**Consultation Response from Mark Berry KC,
Highways Development Management**

2023/90956 rear of, 1, Sparks Road, Oakes, Huddersfield, HD3 4BX

Erection of 5 dwellings

Responding Ref: 2-19SE-3.

PROJECT NO.	DRAWING NO.	REVISION
22216	01	F
STATUS PLANNING SUBMISSION		
SCALE @ A1 varies	DATE Nov 22	DRAWN SS

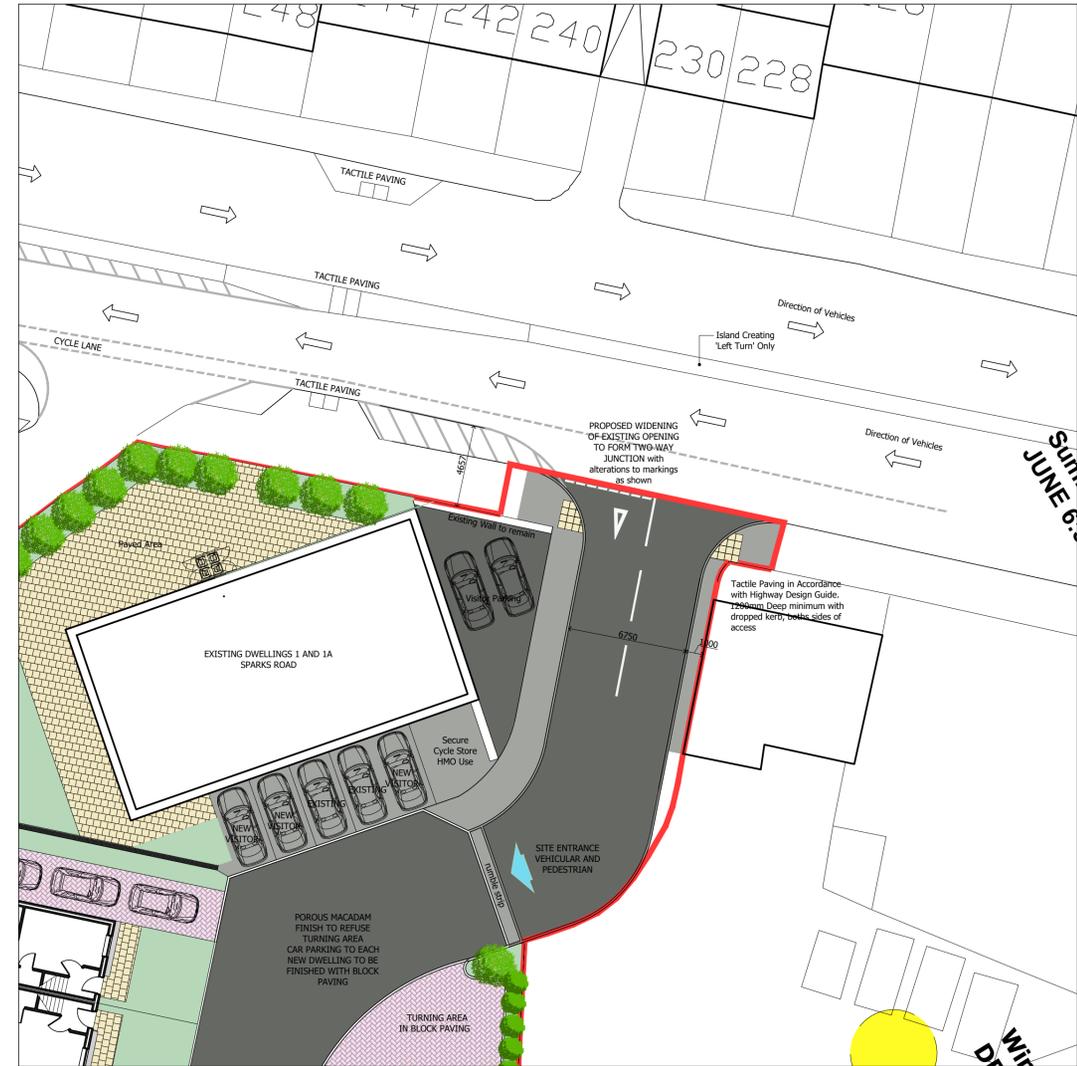
The previous Highways Development Management consultation response dated 25th September recommended that the proposed footway should be re-positioned on the opposite side of the proposed access.

The applicants have now provided revised plan number 22216-01 rev F showing the proposed footway repositioned.

These proposals are therefore considered acceptable.
